Planning Inspectorate

Our ref: OR-0002198/01

Date: 04 June 2026

Application by Photovolt Development Partners (“the Applicant”) for an Order granting Development Consent for the proposed Botley West Solar Farm (“the Proposed Development”)

Title: Illustrative Masterplan
Figure 5.5
 Cable Corridor Plan Overview –
 Land between the Central and Southern Sites east
 and south of Eynsham around the Swinford Bridge

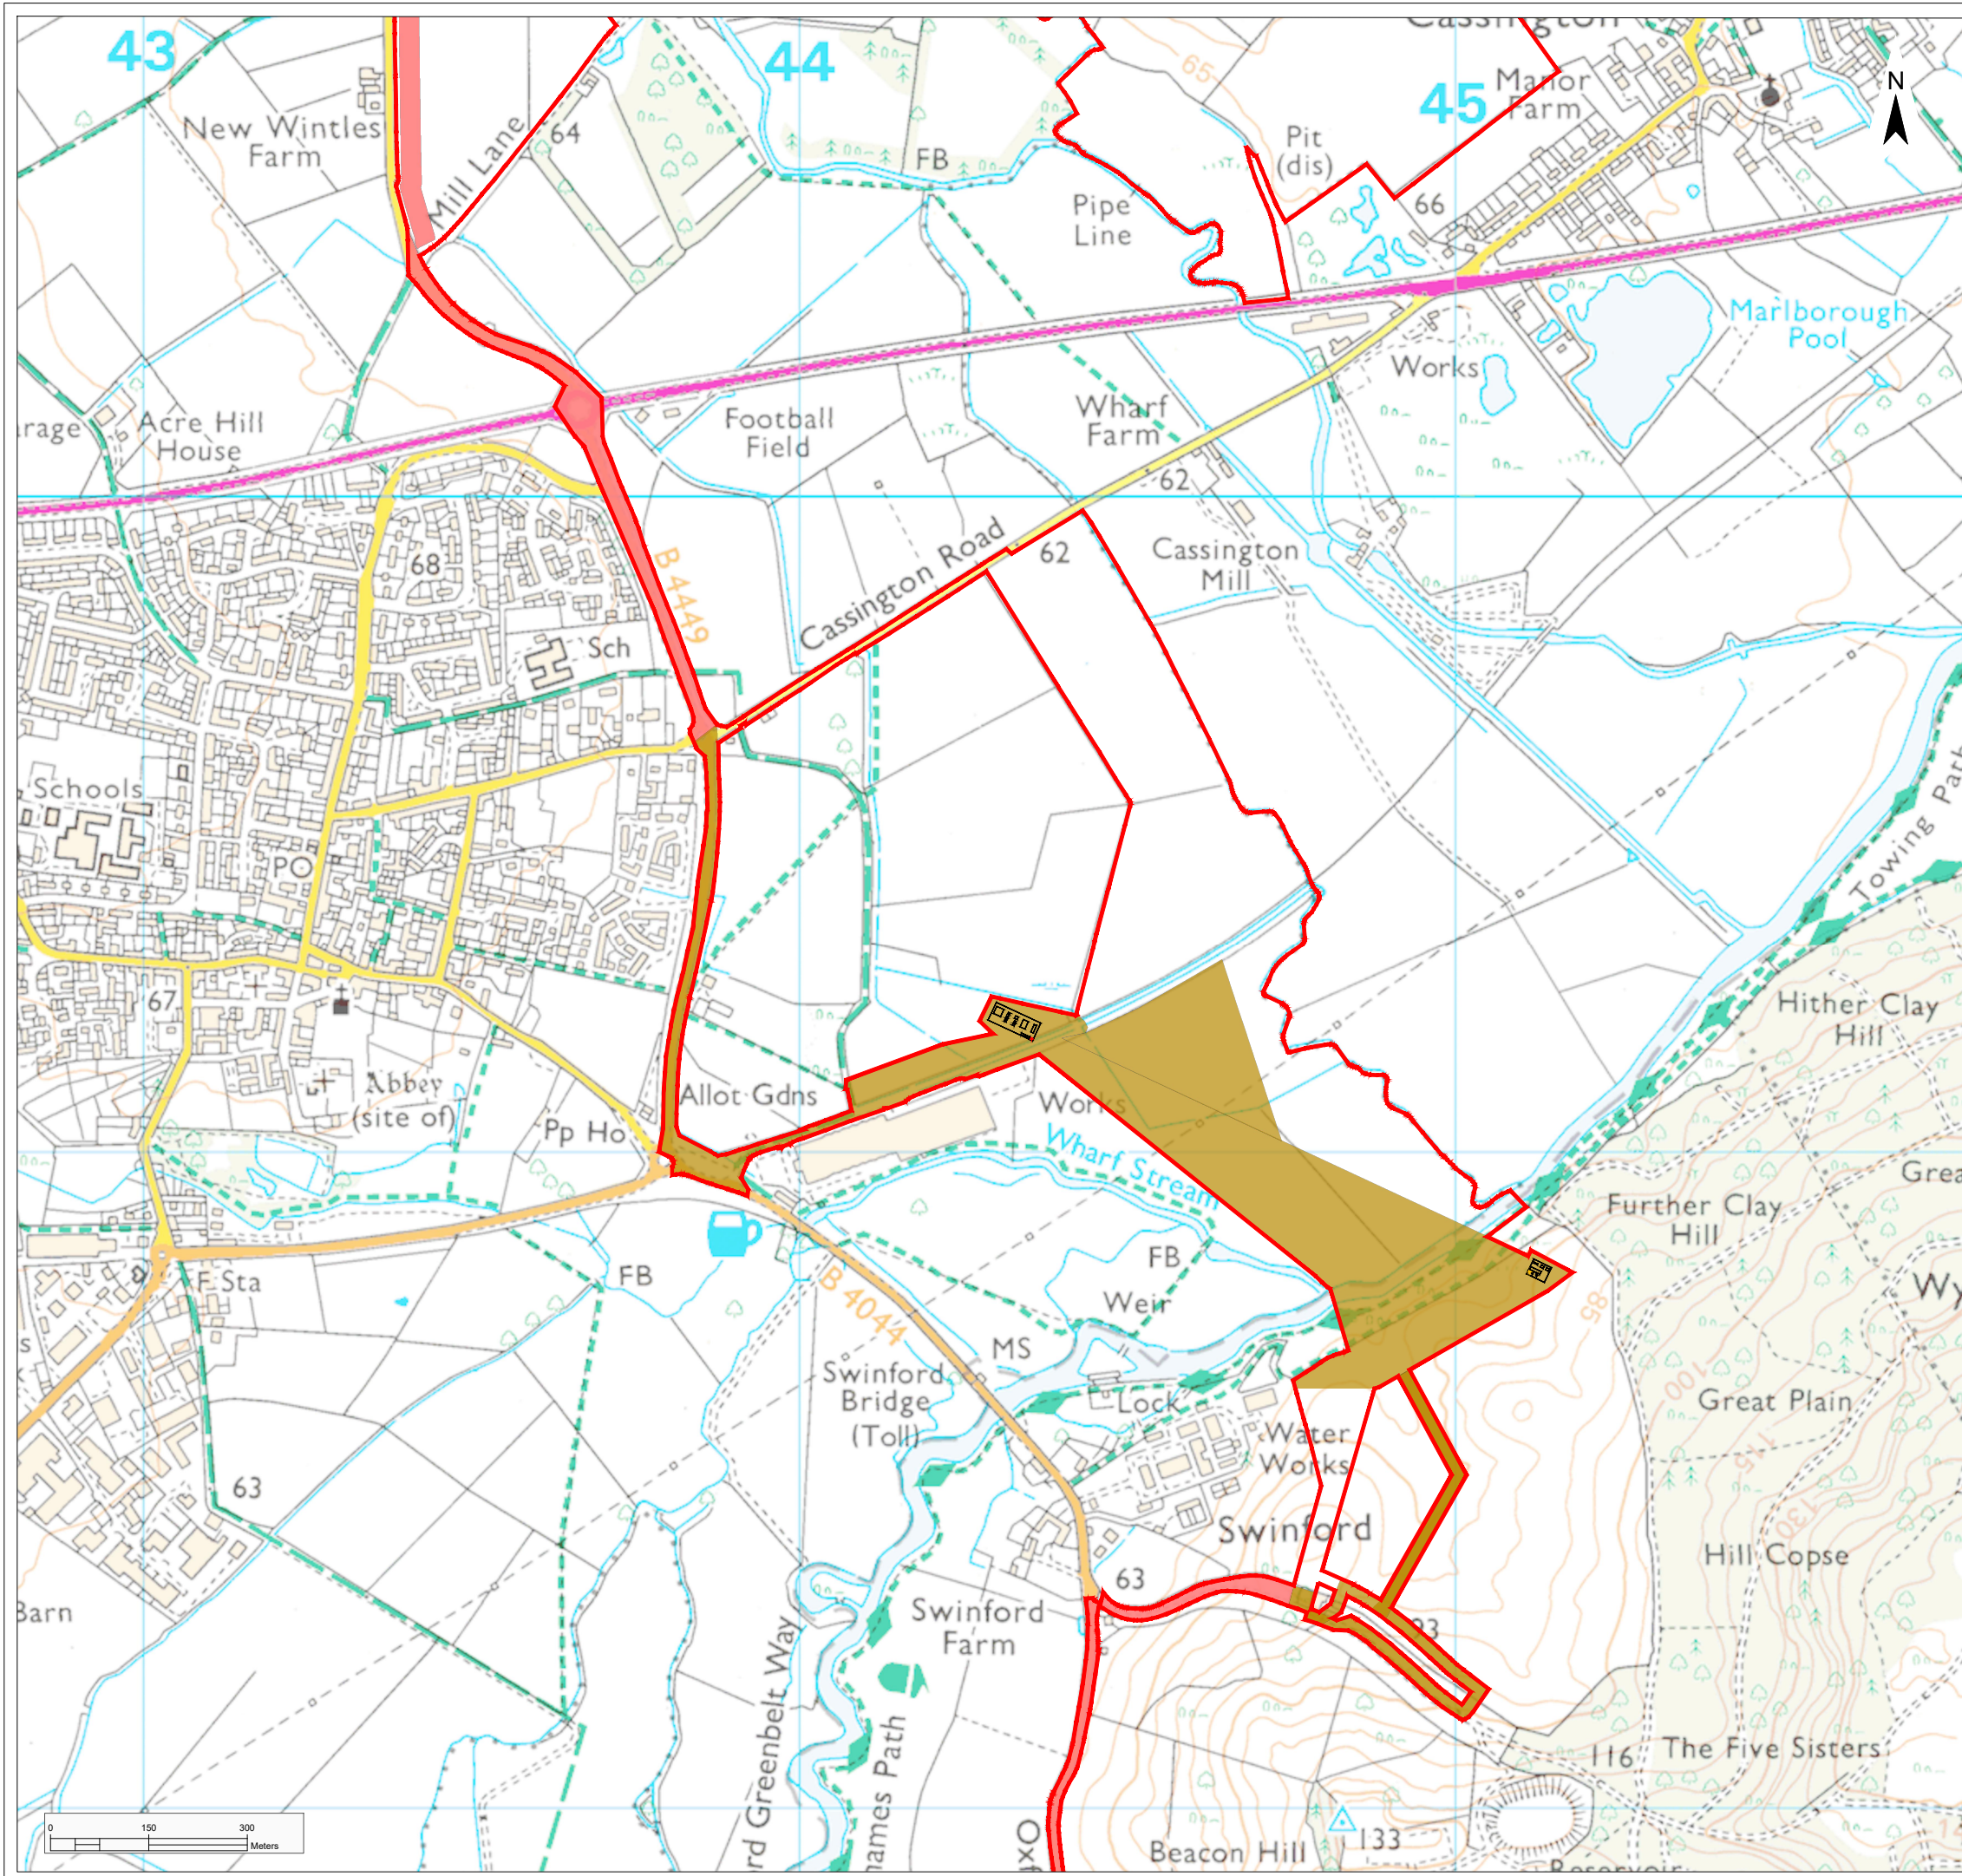
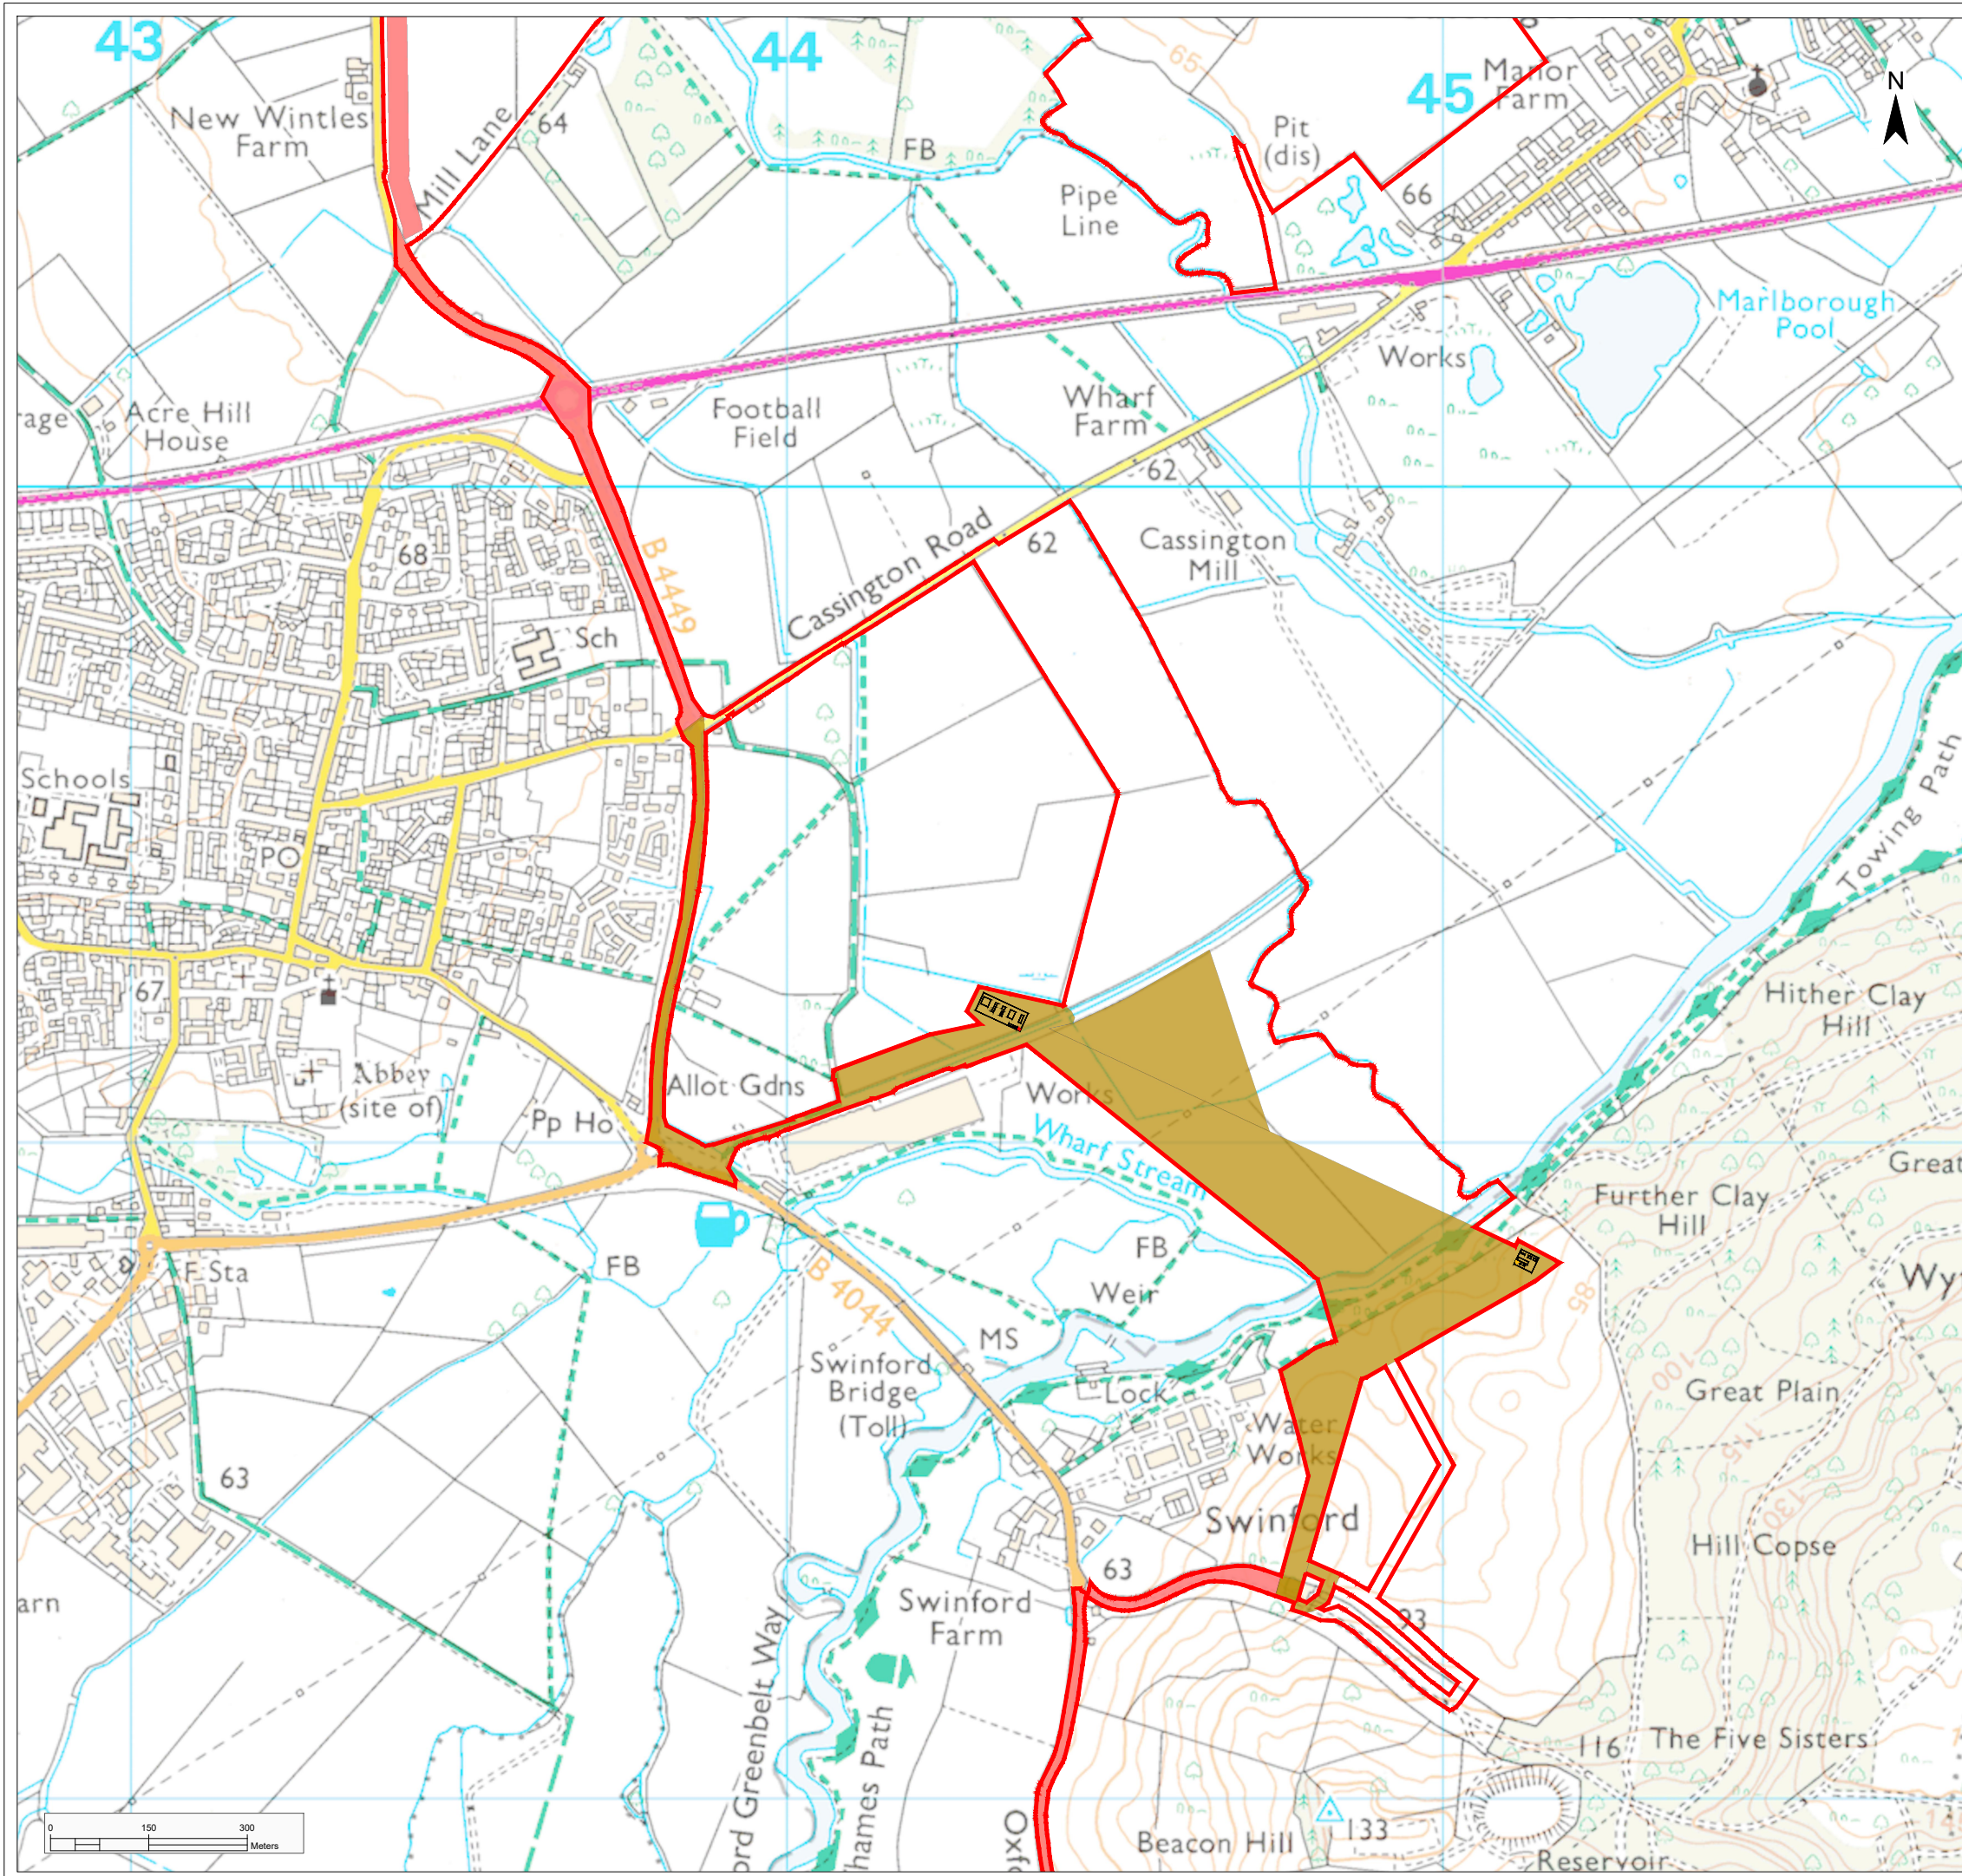
We have reviewed the Hydrology and Flood Risk Technical Note – Swinford HDD Crossings (REP6-054). The applicant has adequately justified why they are unable to move the Horizontal Directional Drilling (HDD) entrance pit at Swinford outside of Flood Zone 3b. We consider this justification is reasonable in the context of wider site-specific constraints.

Considering the proposed mitigation measures, inclusive of the additional mitigation measures (section 1.4.4), if the applicant complies with these, we consider that the approach is reasonable.
